**Consultation Response from KC,  
Highways Development Management****2024/92779 land at Providence Street, Earlsheaton, Dewsbury, WF12 8HZ****Outline application for residential development****Date Responded: 8-4-2025.****Responding Officer: Mark Berry,****Responding Ref: 15-6SE-13.**

DRAWING:
ILLUSTRATIVE MASTERPLAN

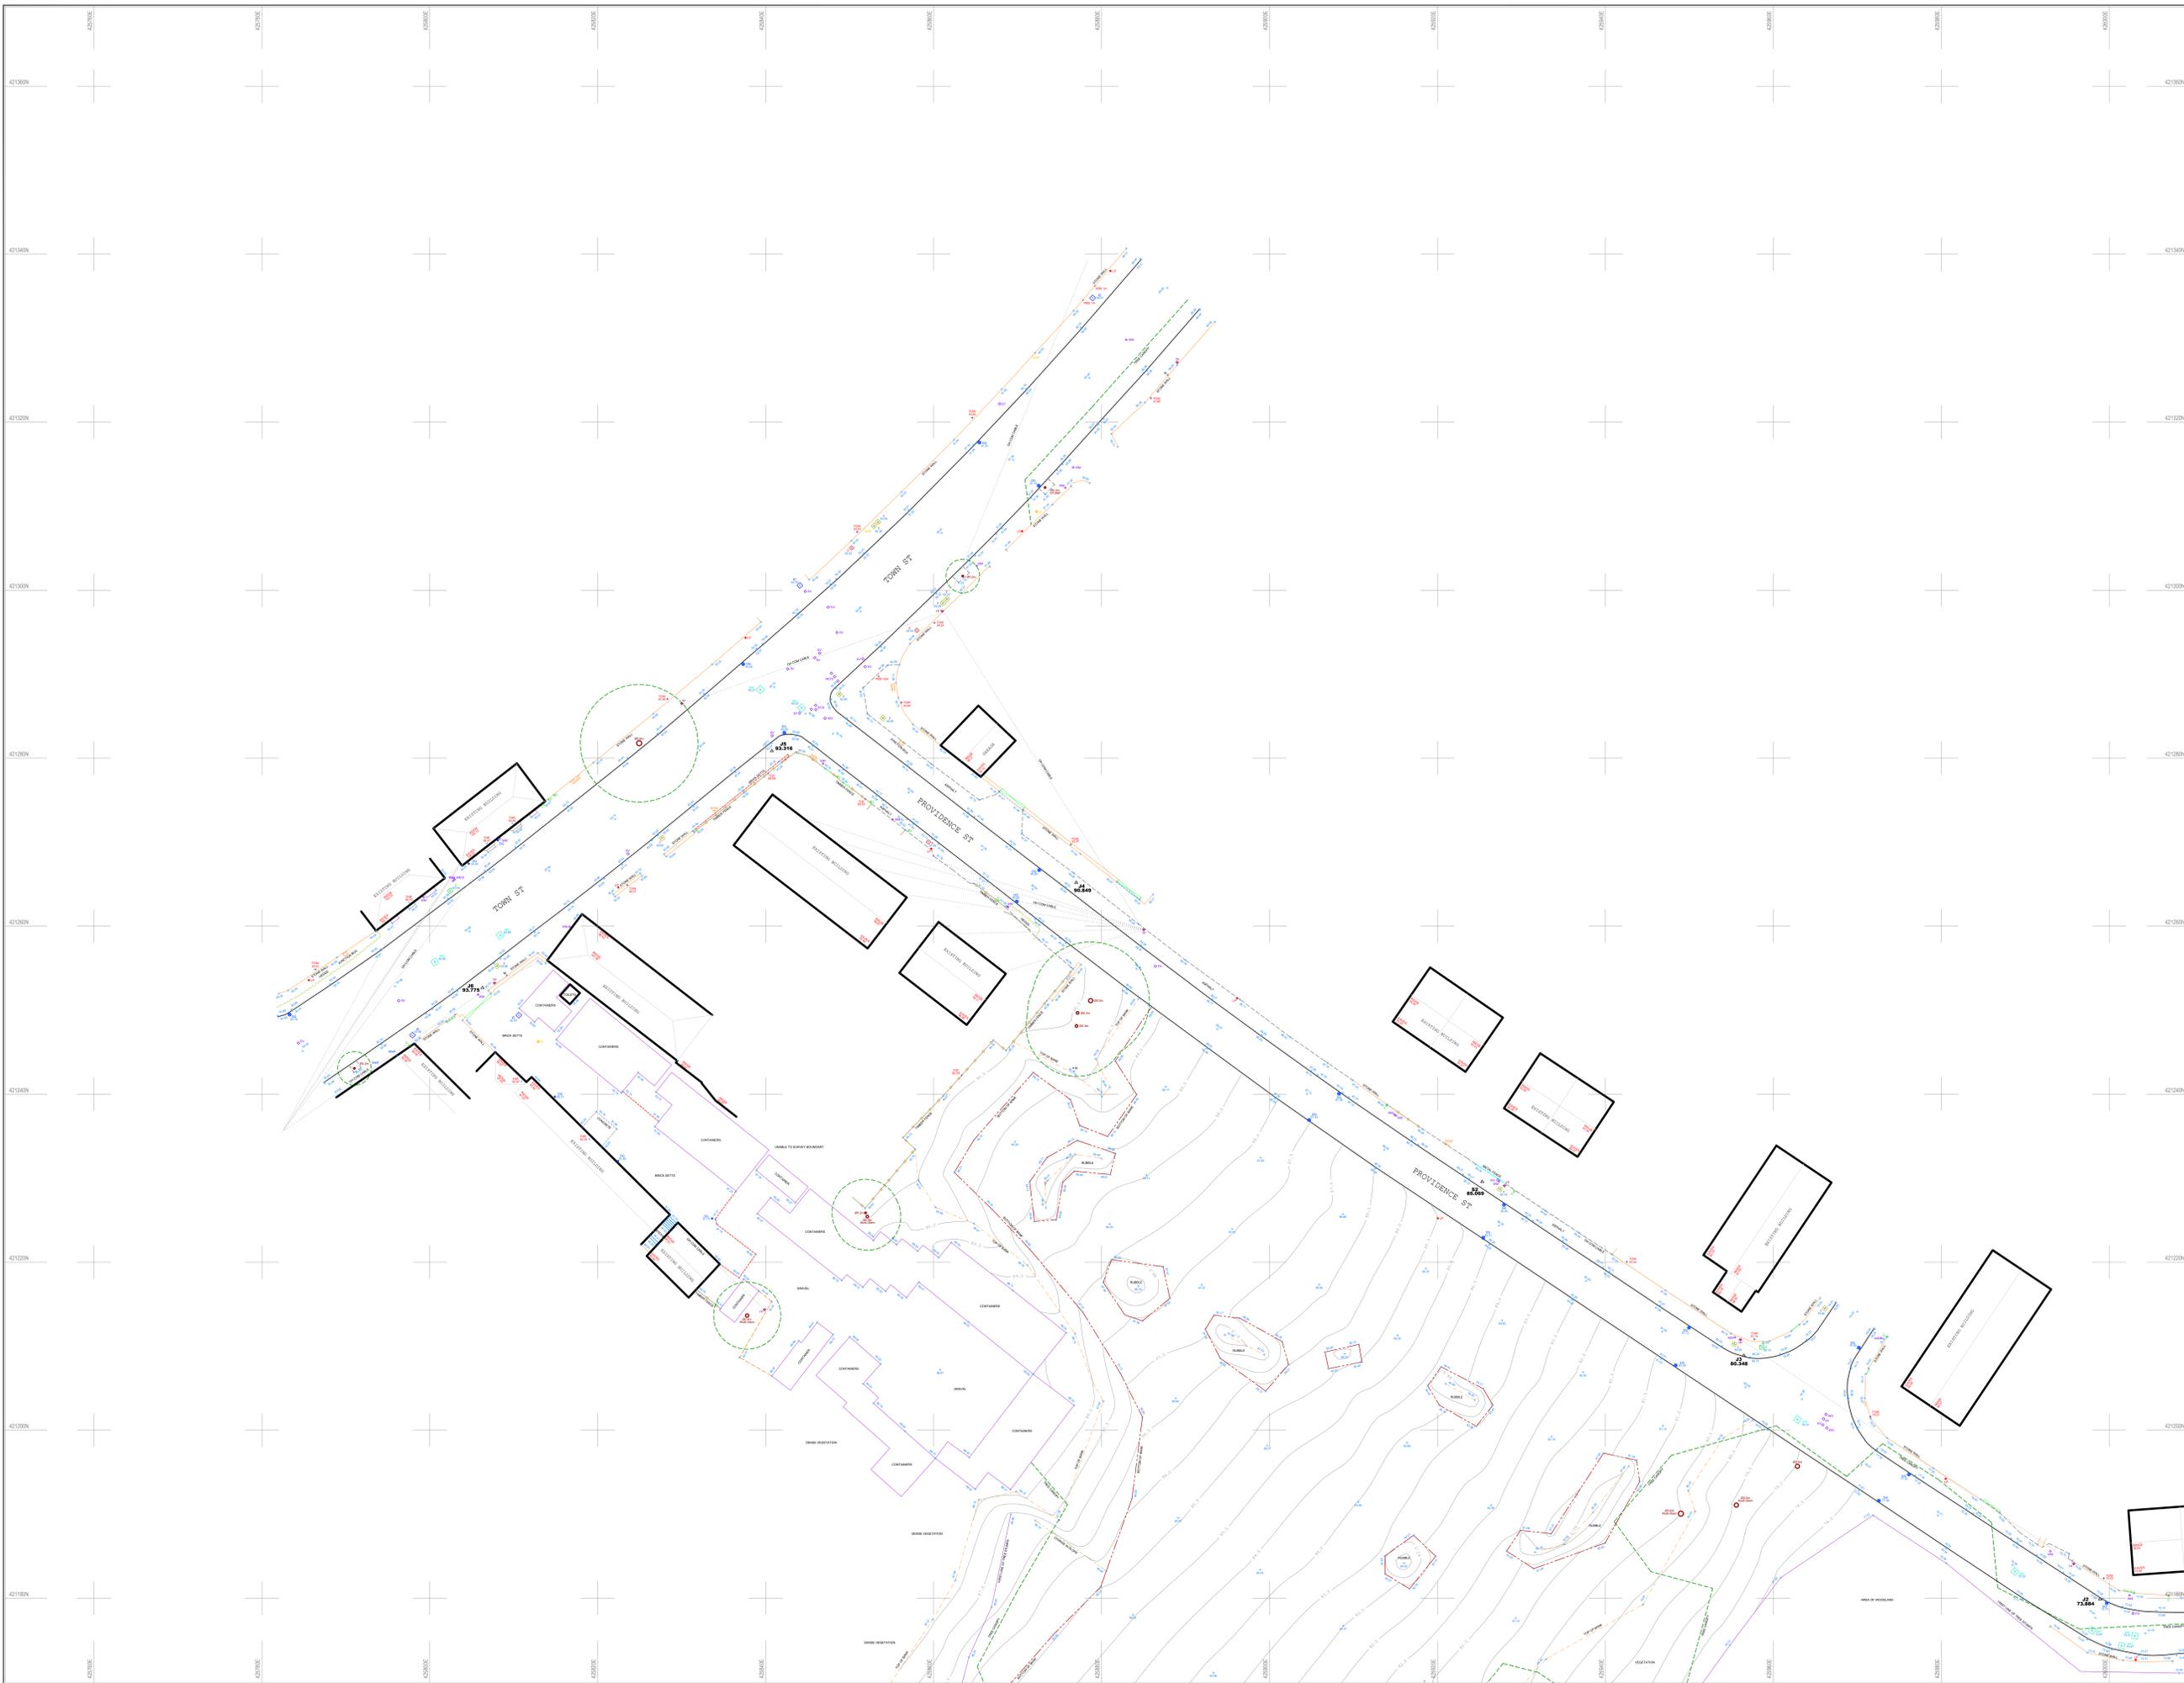
**Illustrative Master Plan.** This is indicative only and shows how the site could be developed.

30 TOWN STREET/SYKE LANE SUBJECT TO 30MPH SPEED LIMIT

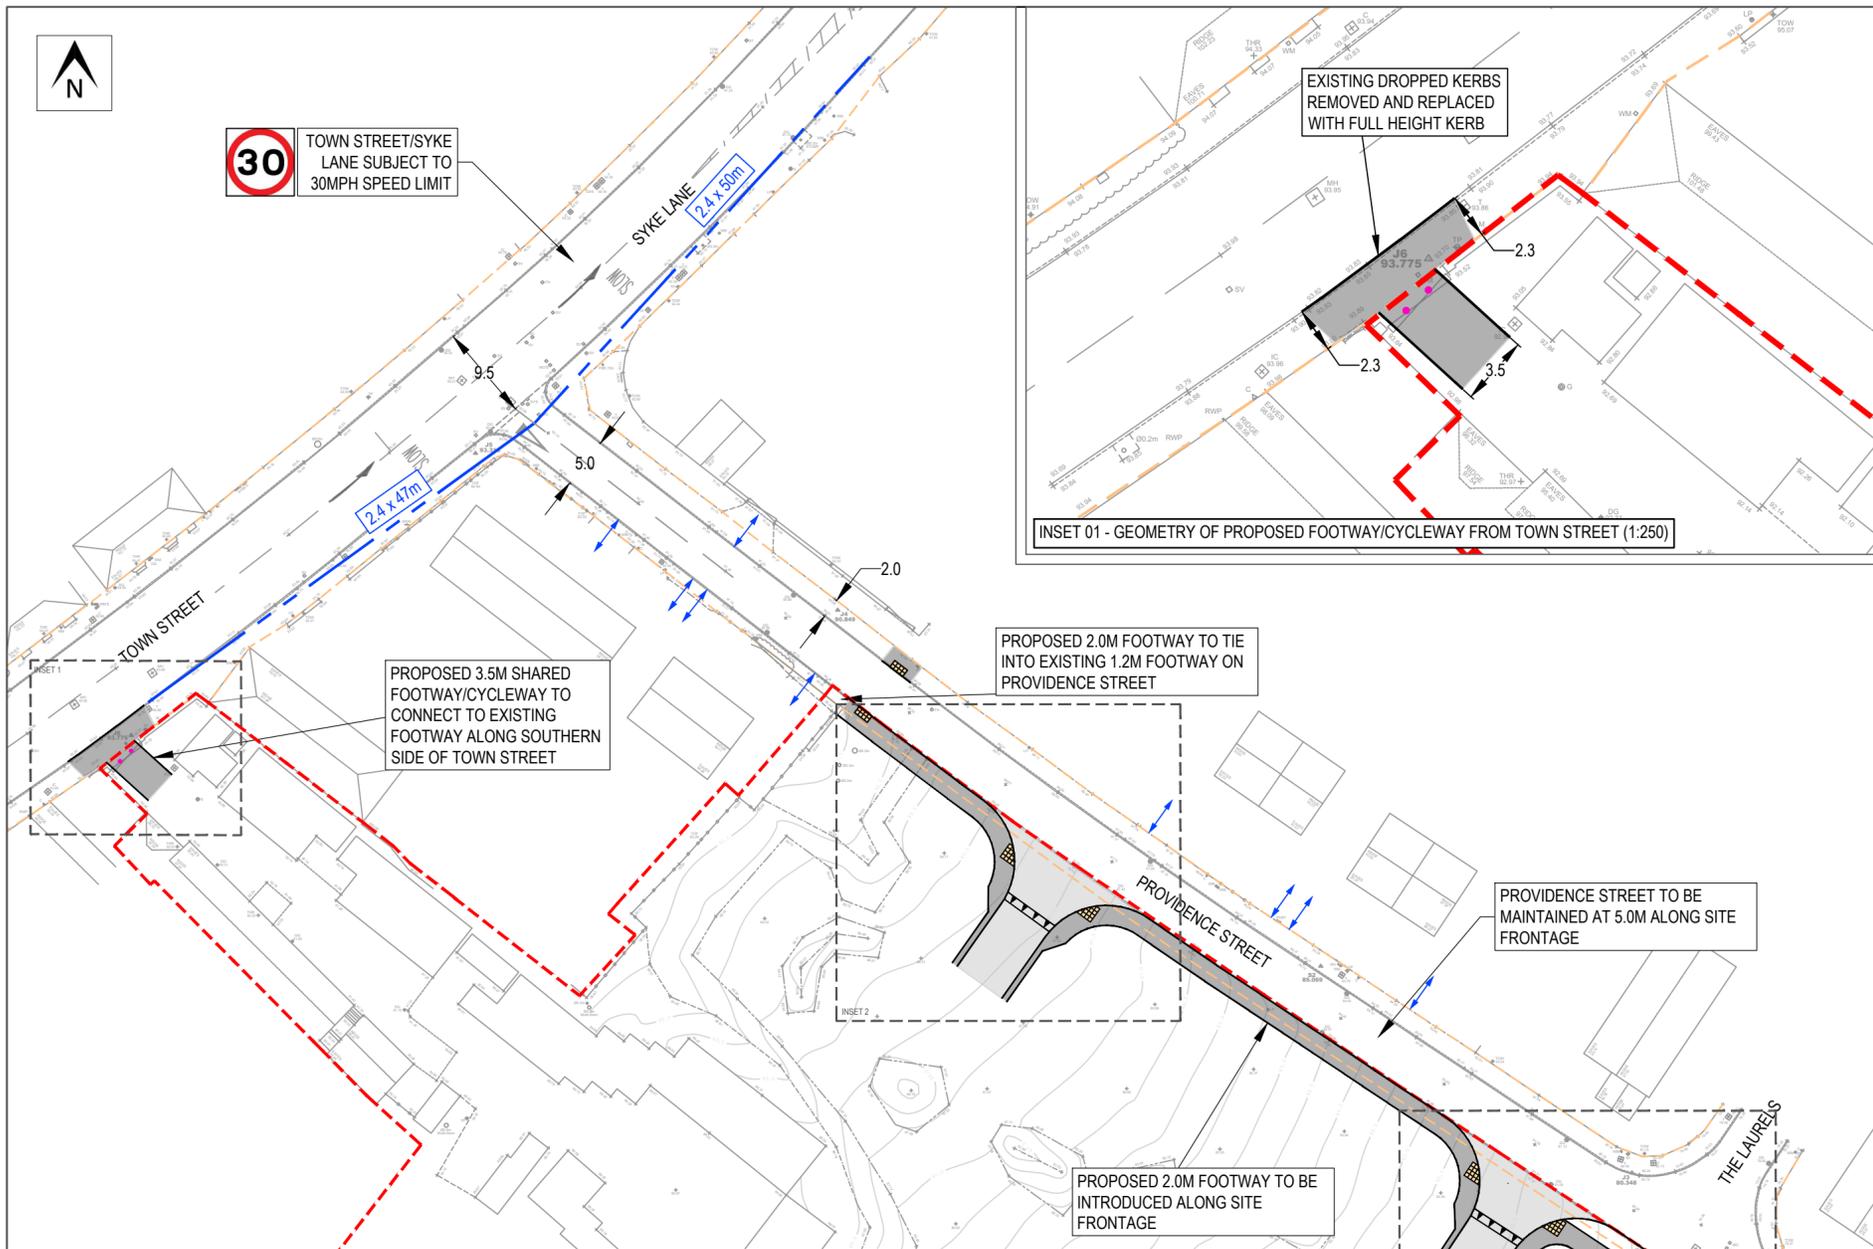
**Site Access Arrangements Plan** shows 6m junction radii on to Providence Street, a footway only link onto Town Street with the Town Street vehicle dropped crossing reinstated and bollards provided, footways extended into the site and a 2.0m wide footway to the site frontage.

Whilst the revised plans address most of the points raised in the highways consultation response the refuse vehicle swept paths are far too tight to kerb lines and are not considered acceptable.

All schemes must incorporate reasonable tolerances and safety margins. A good starting point is to allow 0.5m clearance to kerbing or vertical obstructions on each side of the swept path. Designs should therefore aim to cater for vehicles larger than the above minimum standards.

Vehicle speeds when manoeuvring RCVs, pantechincons, and other LGVs shall be able to travel at a minimum speed of 5 km/h forward and 2.5 km/hr reverse. In other words, drivers shall not need to stop to adjust the steering while stationary before setting off again.
